Aldington and Mersham Support Group Submission for Deadline 4 (11th March 2025)

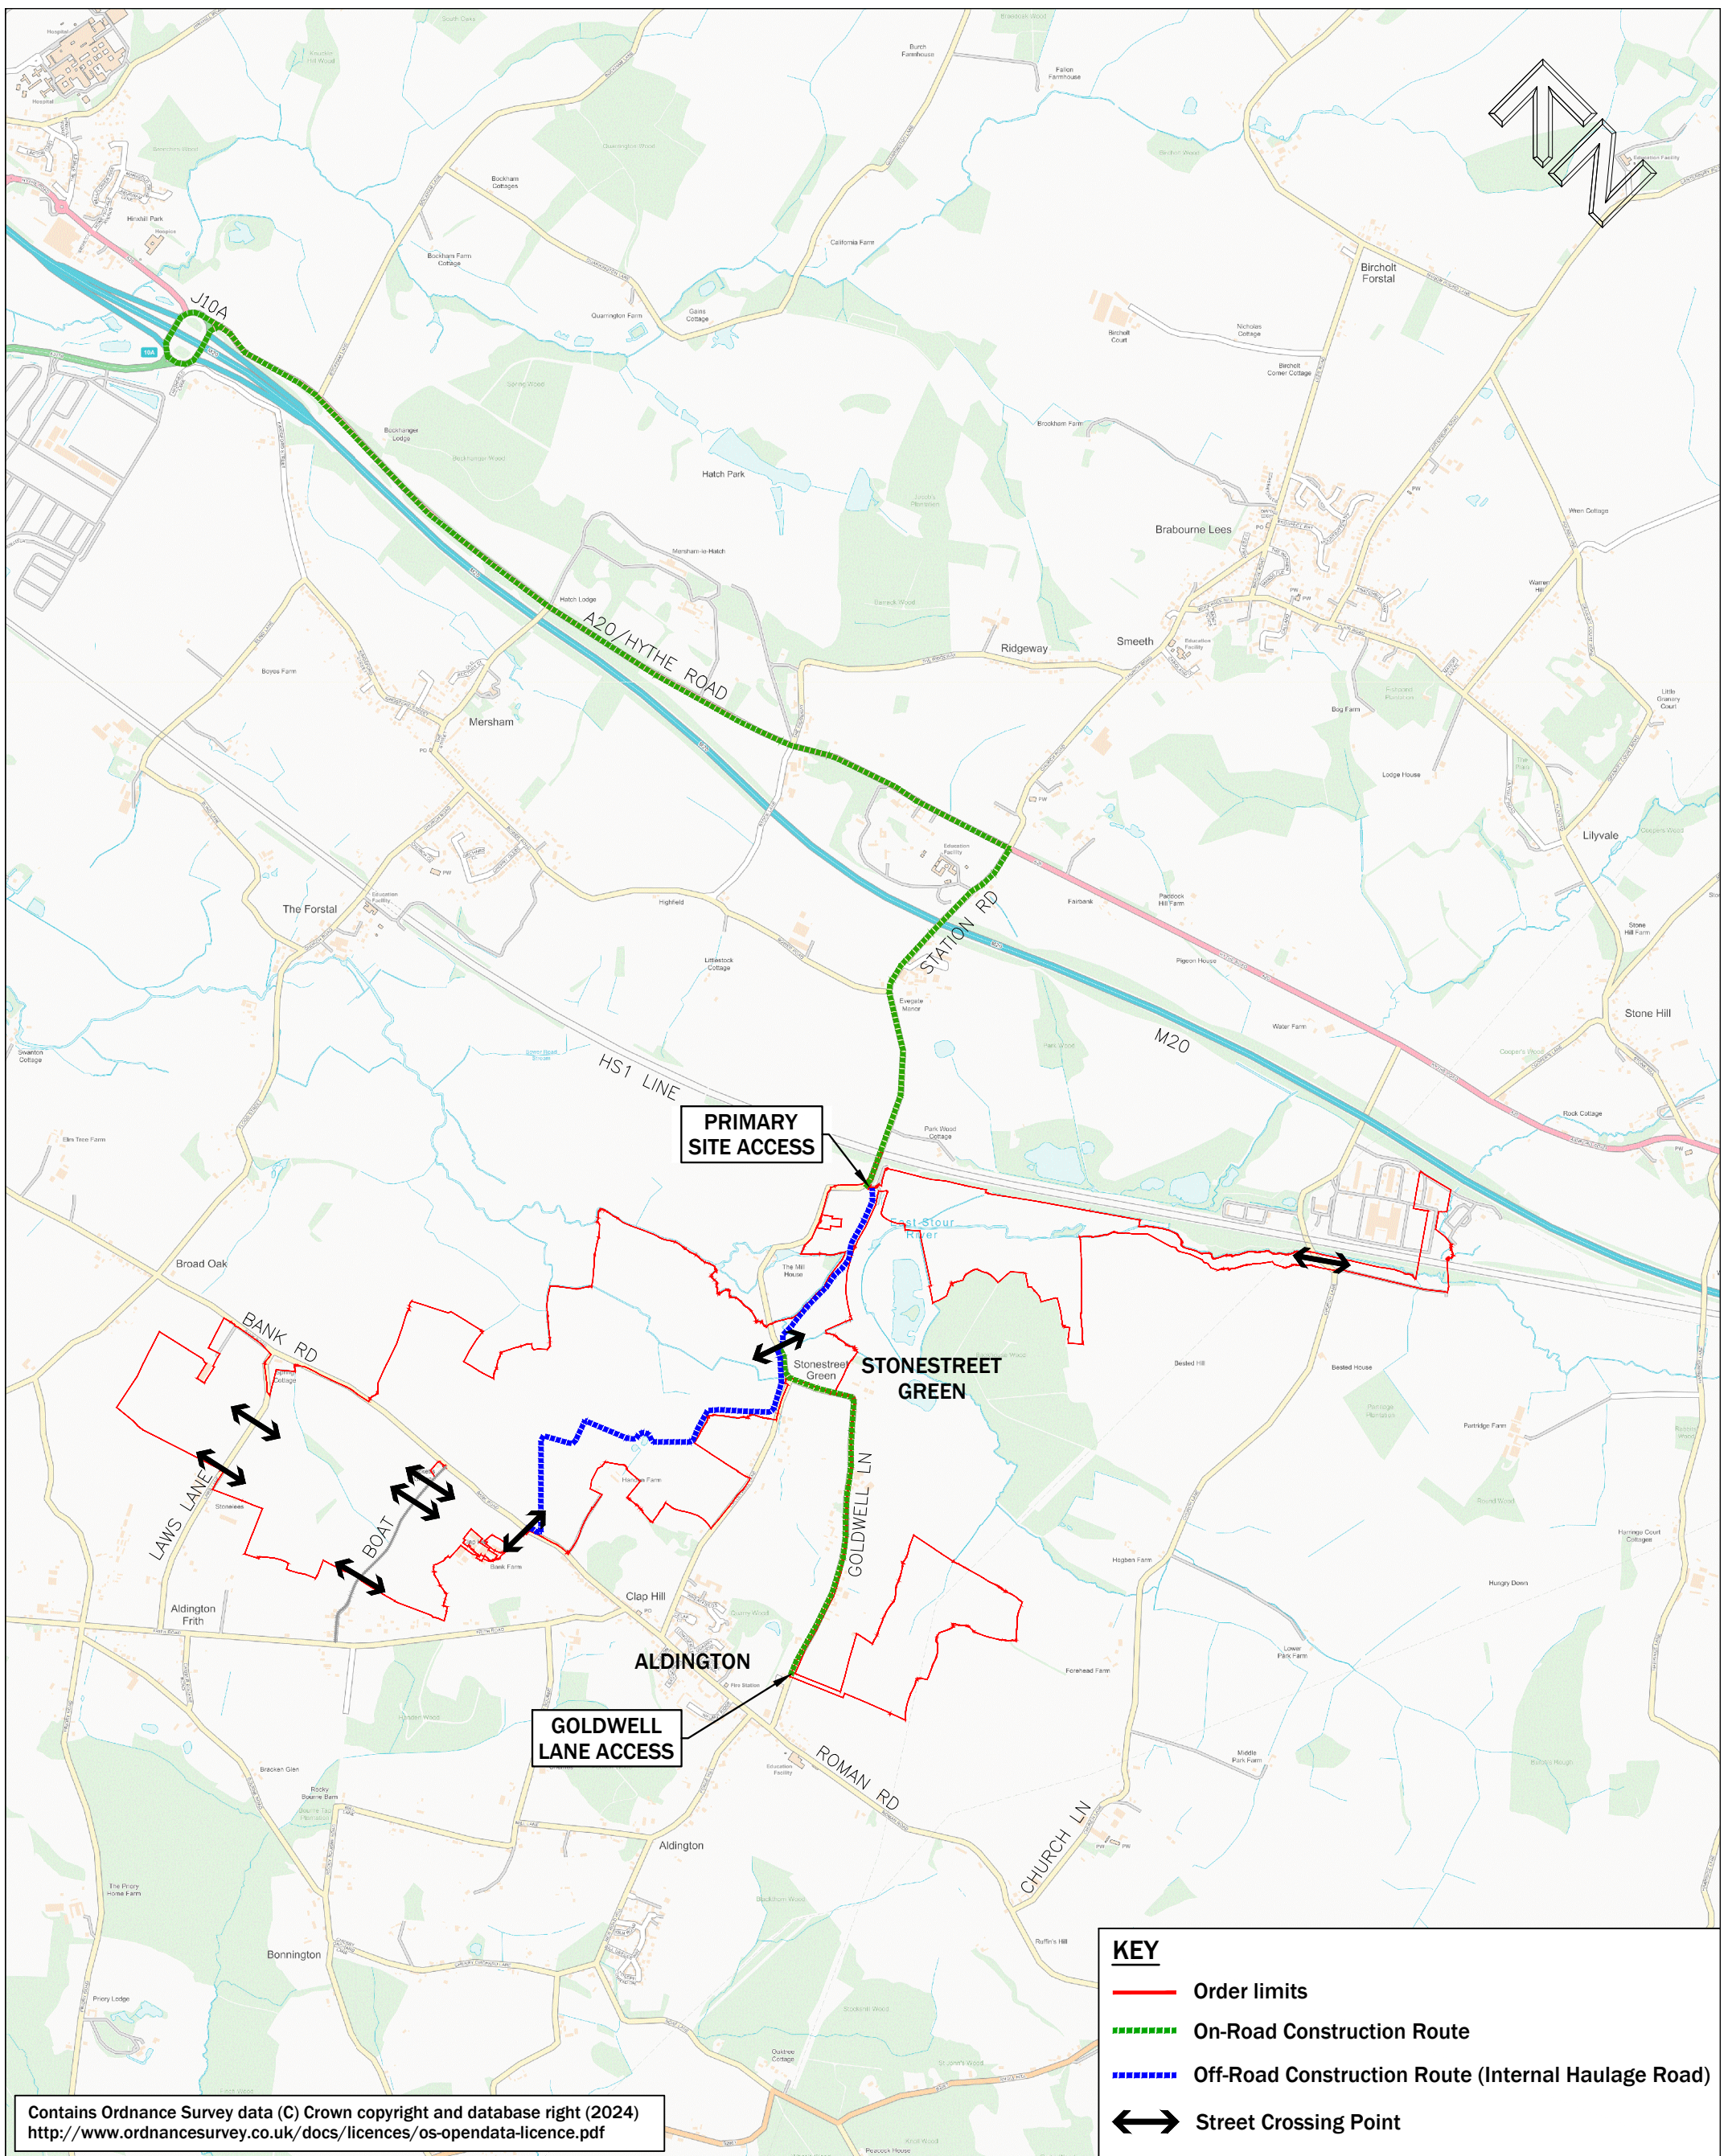
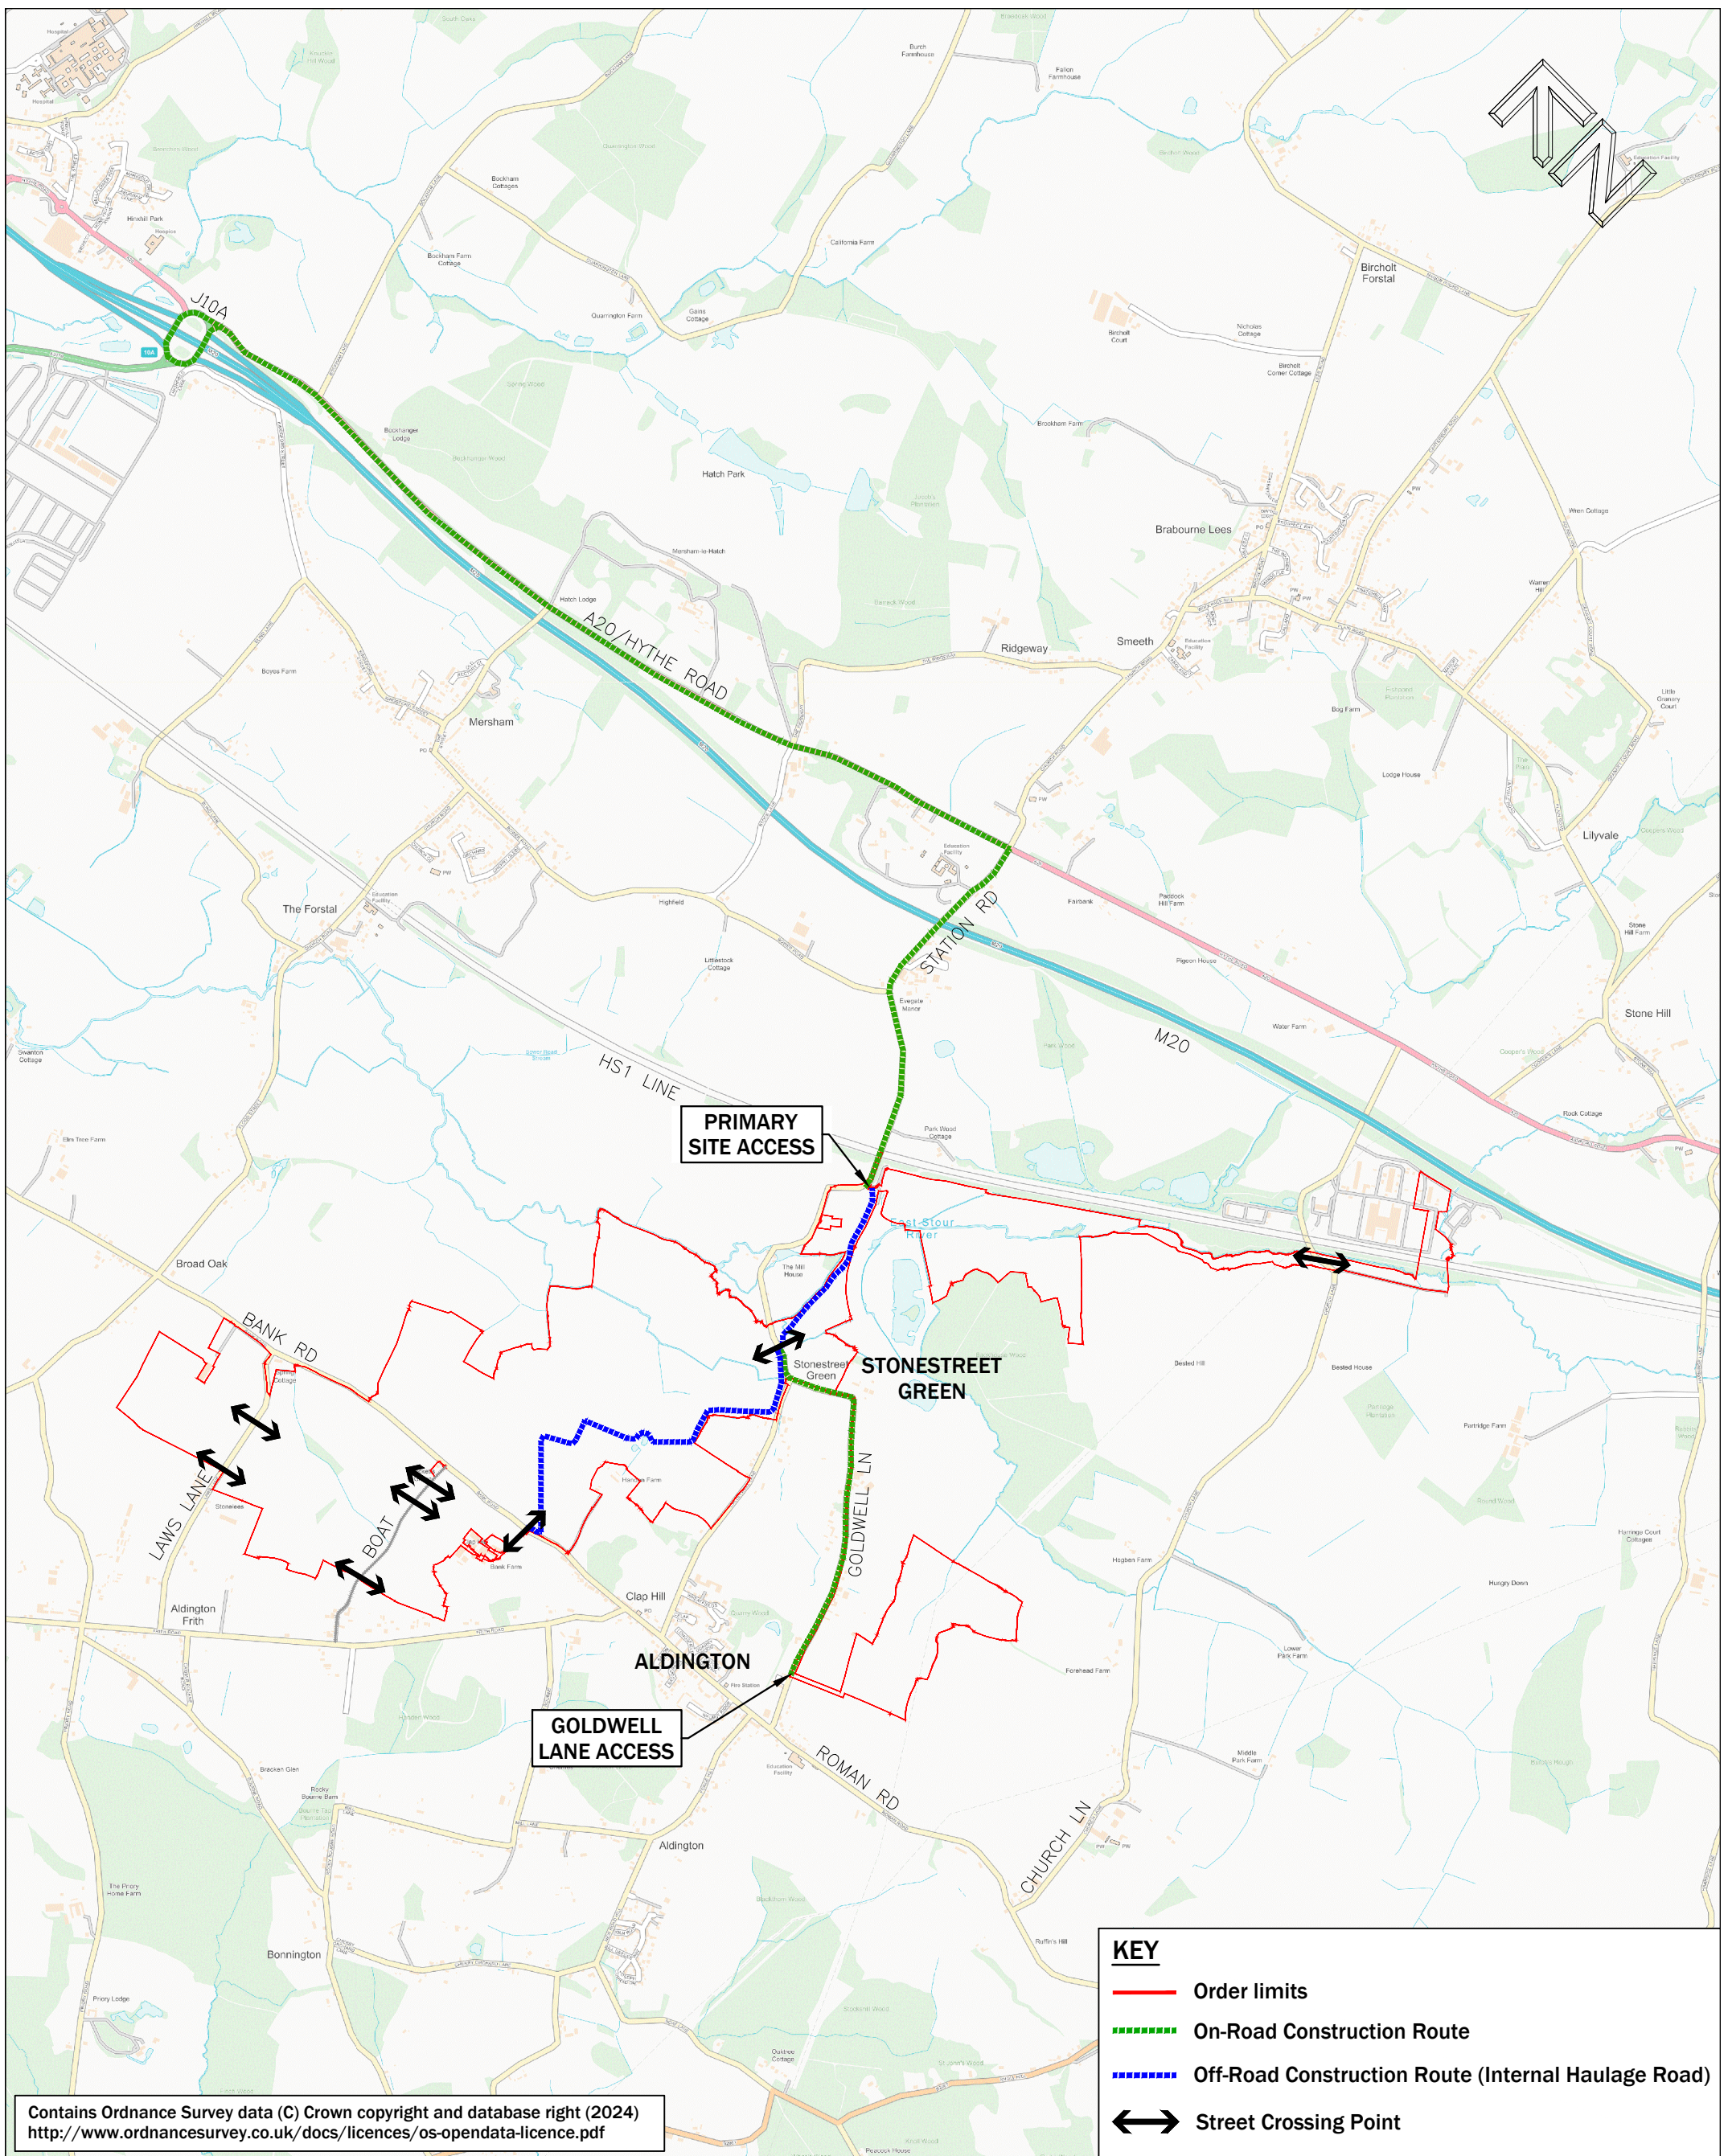
- The tracked changed version of the current OCTMP (**REP1-047**), reveals that the so-called “updated information” involves just two new sentences as follows: -

“The majority of staff will be transported to / from the Site by mini-bus”.

“At least two mini-buses will collect workers from designated collection points”.

On this basis nothing has changed. This wording will almost certainly find its way into the CTMP, ignoring the fact that construction traffic has been seriously understated.

- The expert for the applicant stated at the ISH that 4 No. Articulated HGV could wait in the ghost lane. They cannot. Not even three can fit in it.
- Neither the applicant nor KCC have responded on the point about parts of Goldwell Lane being as narrow as 4 m making it impossible for it to remain open.
- Why does the “40% uplift” in the predicated site traffic provide any comfort? When applied to the predicted “75% of the workforce” using one of the *two minibuses* it still means that more than 50% of staff are assumed to be using these two minibuses.
- Meanwhile, the Exa’s request for the applicant to indicate what means it has considered for incentivising workers to use the minibus service rather than their own cars has been met with a deafening silence.
